ARMONIA RANCH VACATION PLAT

Vacating Lots 6 to 14; Dark Sky Trail, Twin Pines Road and Certain Easements, all Located in Section 14, Township 12 South, Range 69 West, of the 6th Principal Meridian, Colorado.

POD File # VR232

ARMONIA RANCH VACATION PLAT

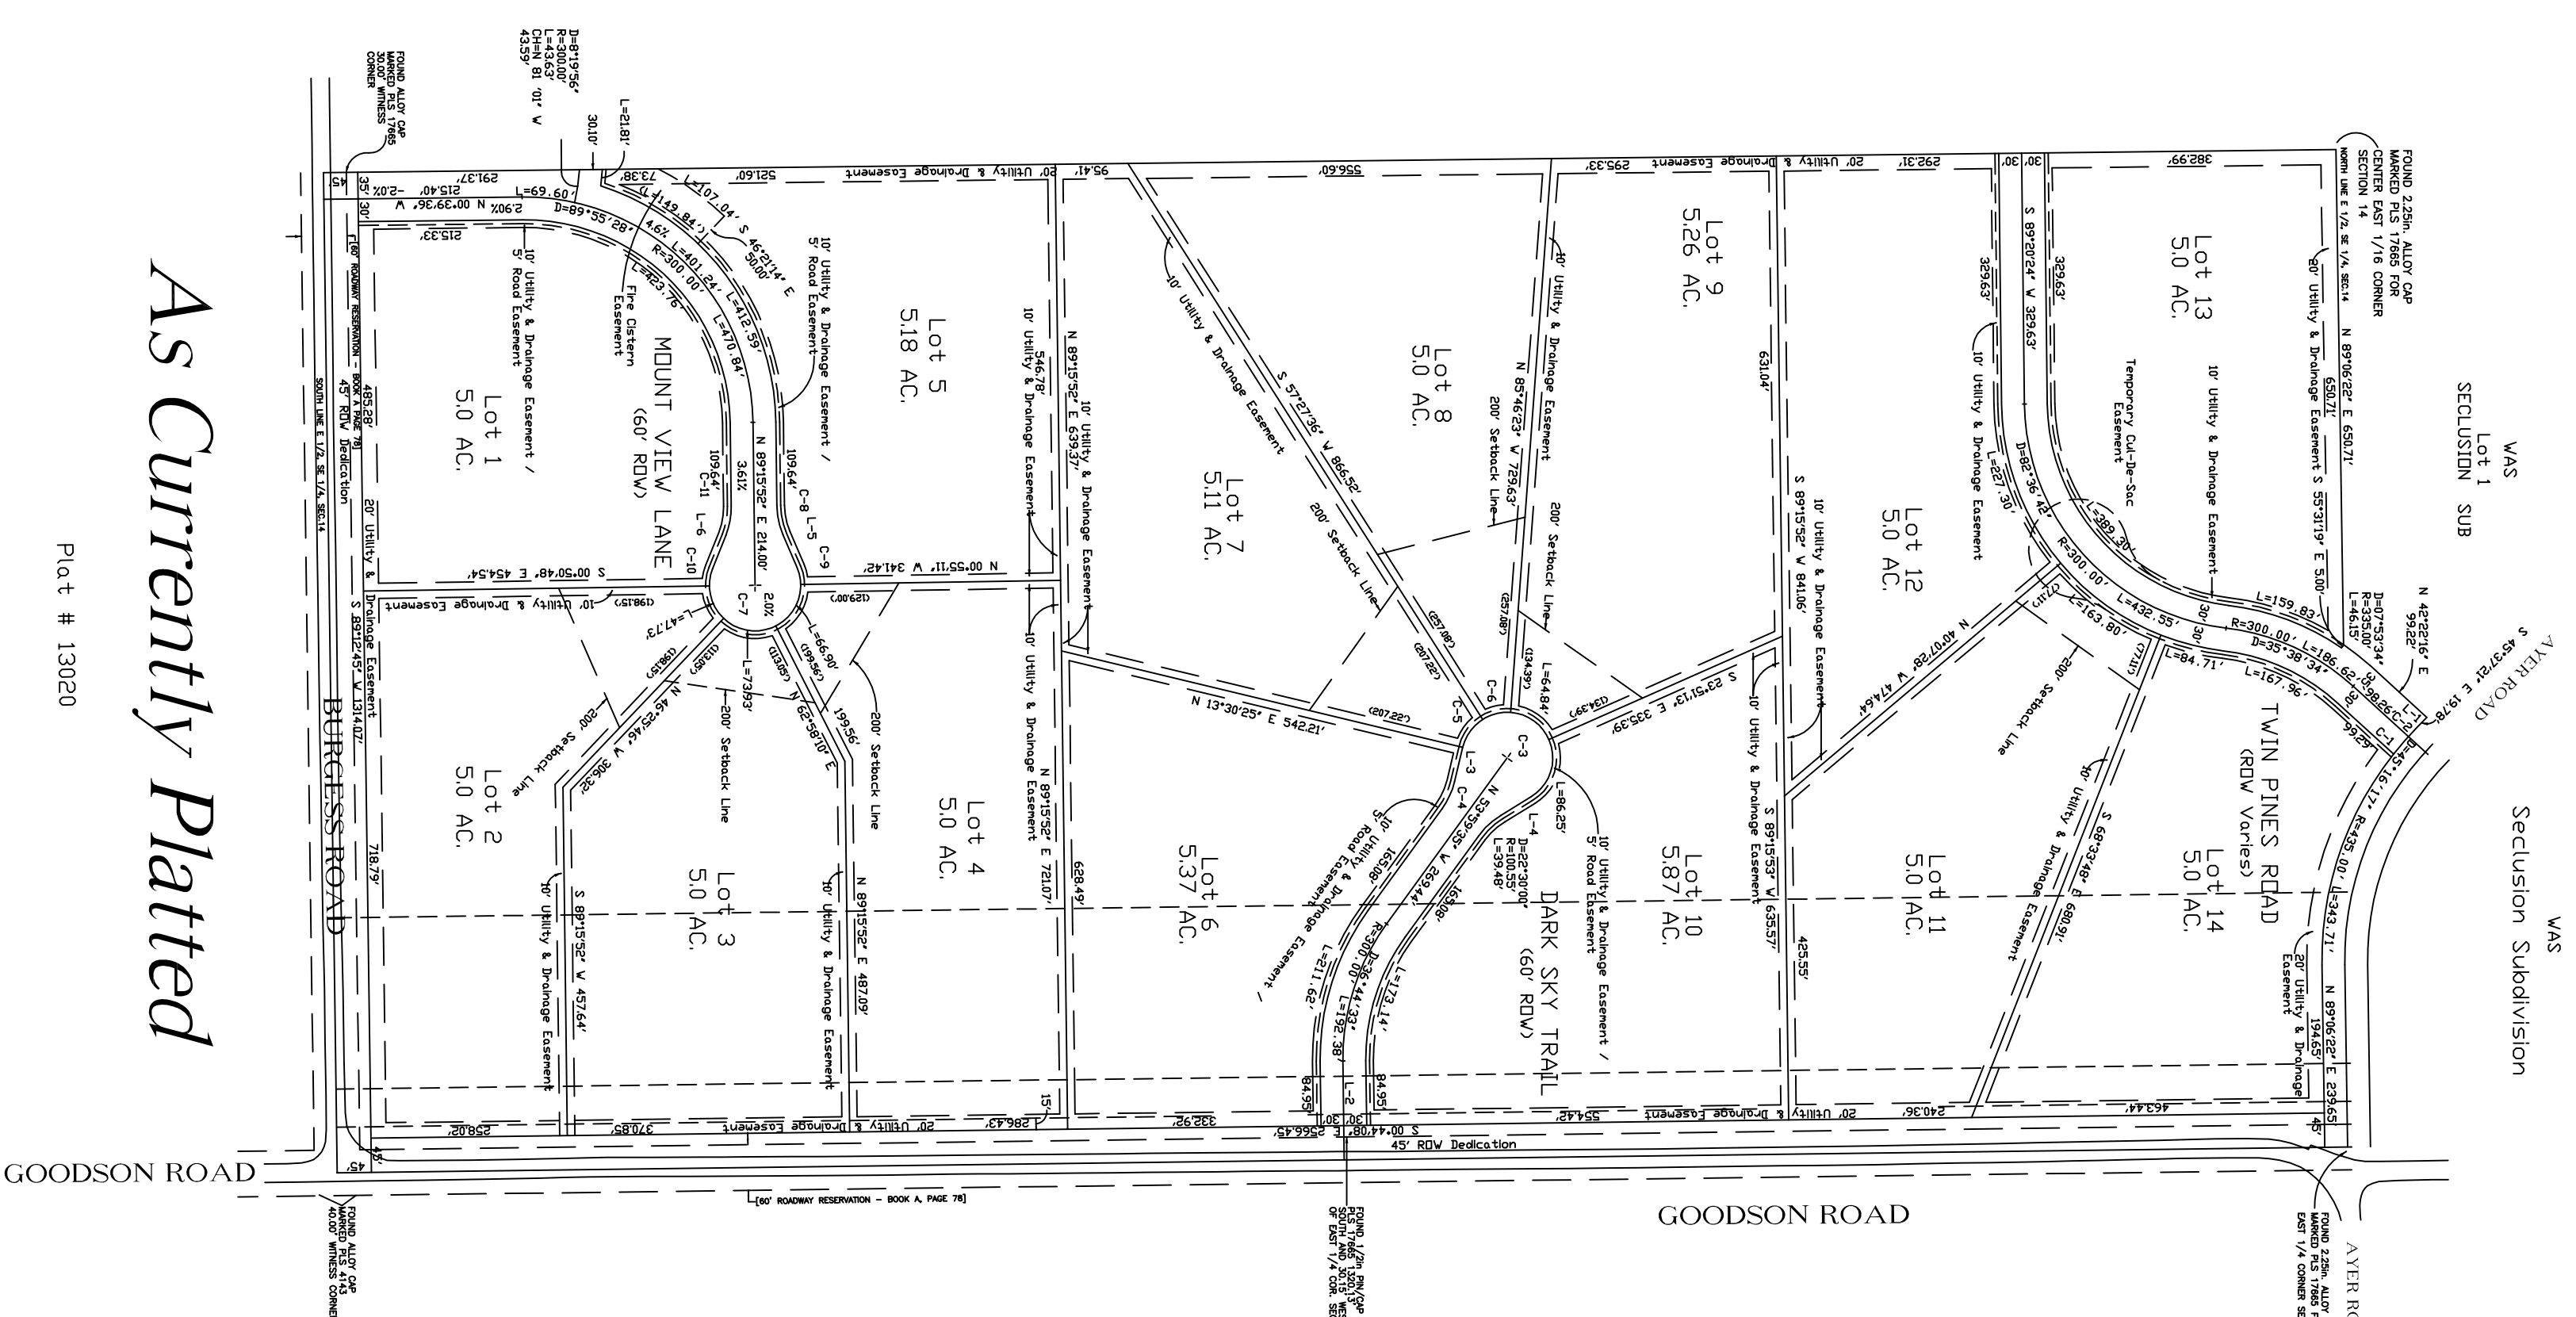
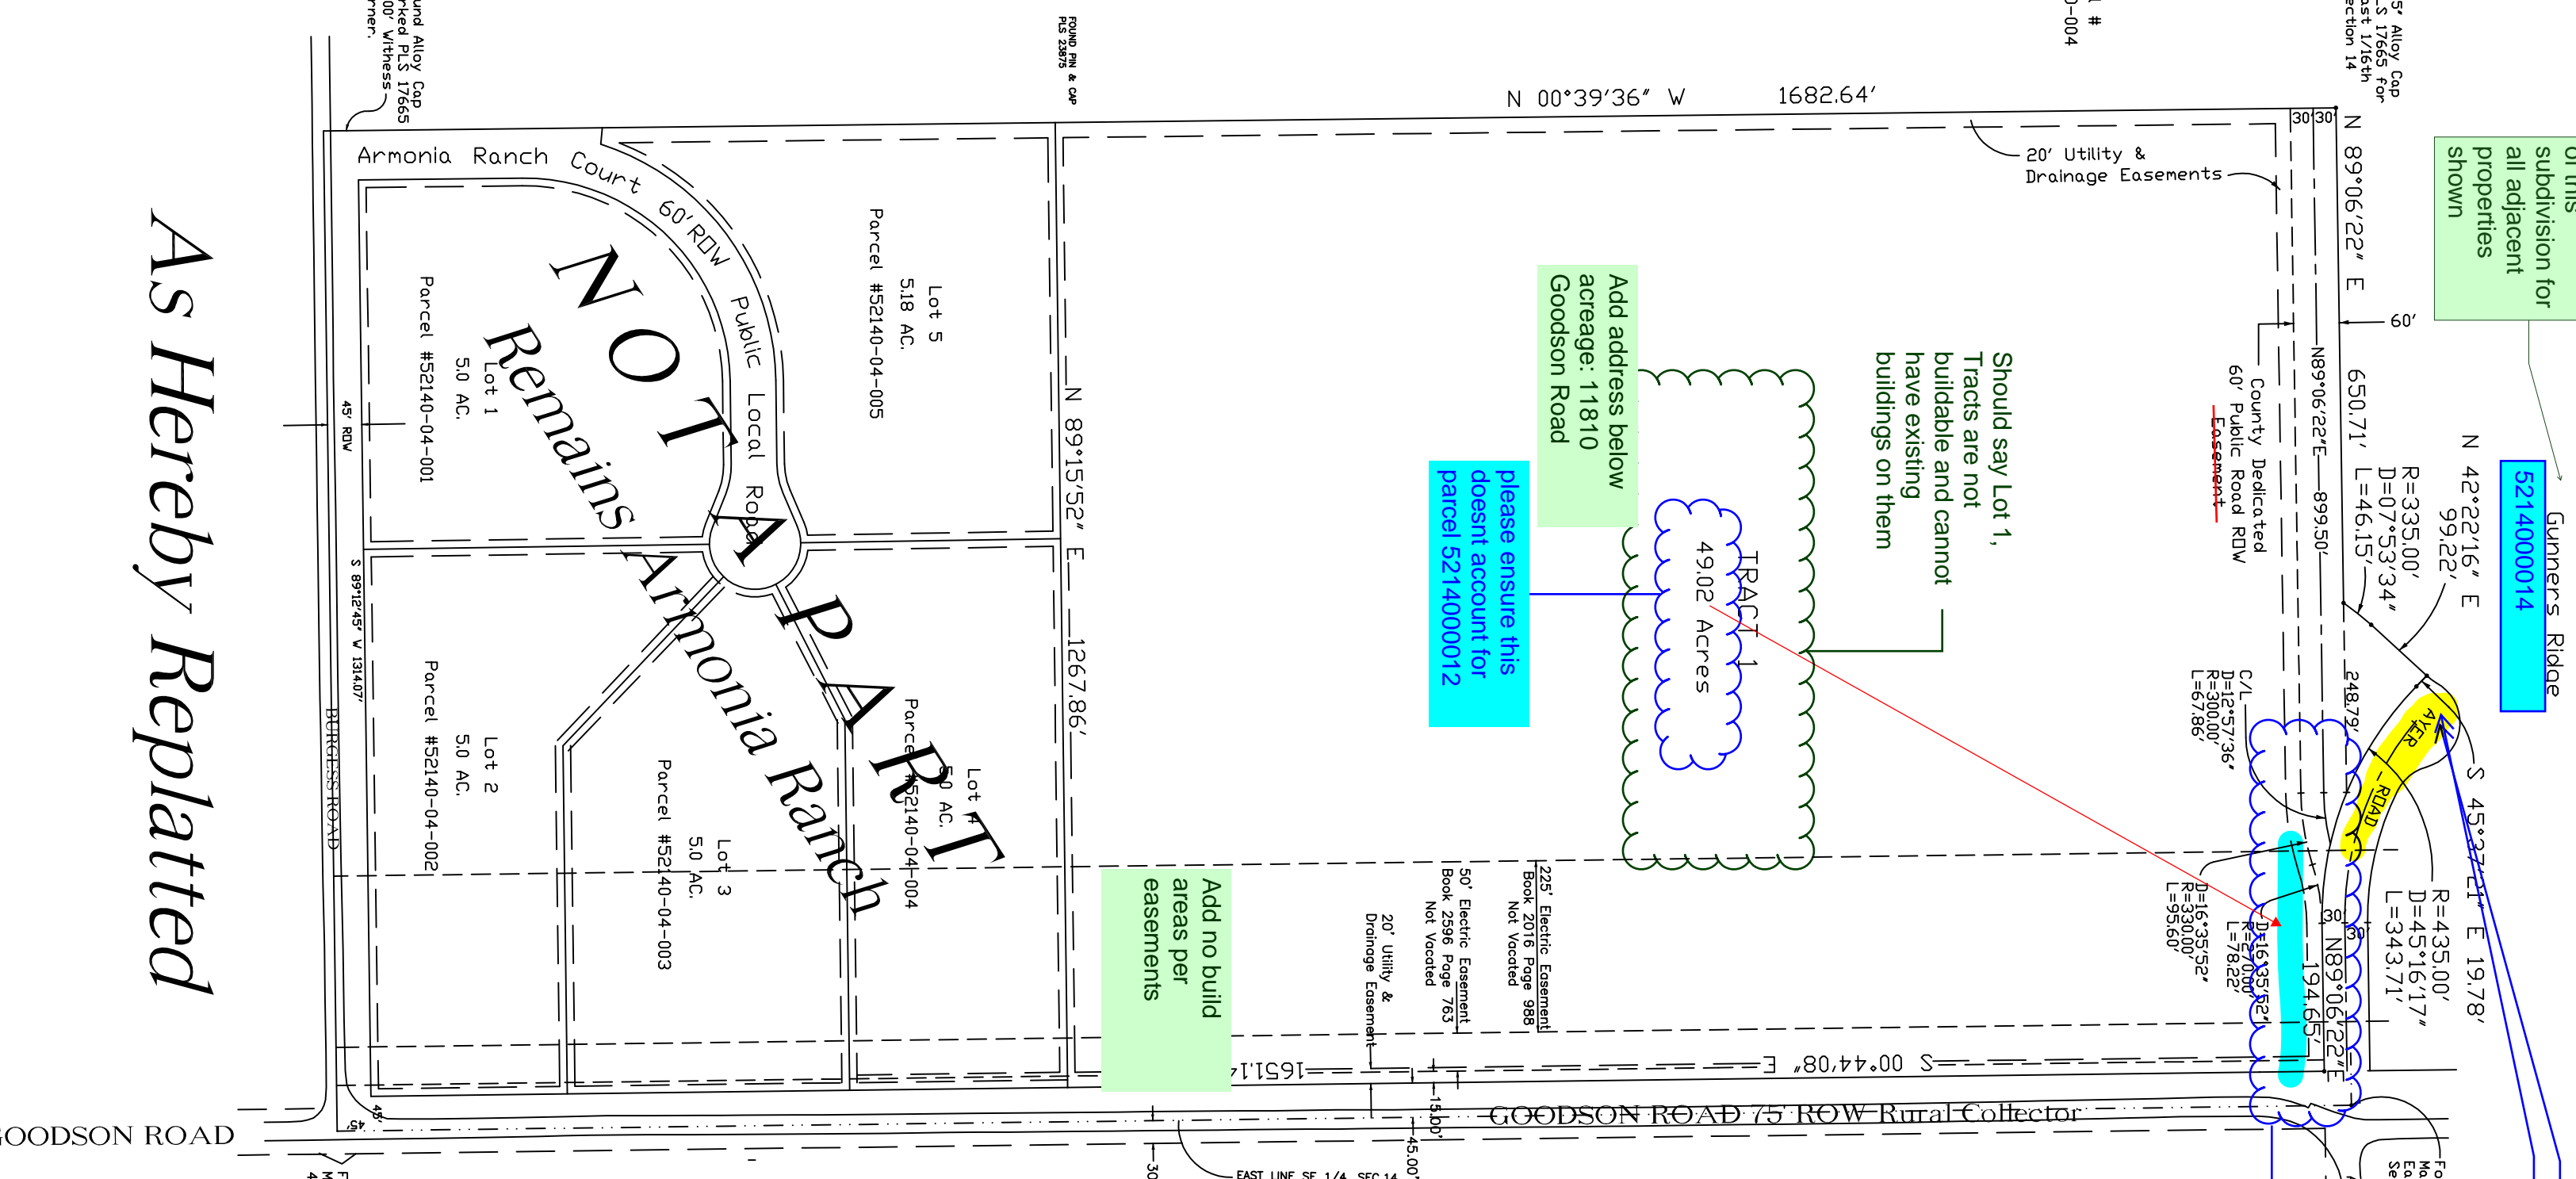
Add missing notes

Add Goodson Road ROW and classification Rural

Add Plat # 13020
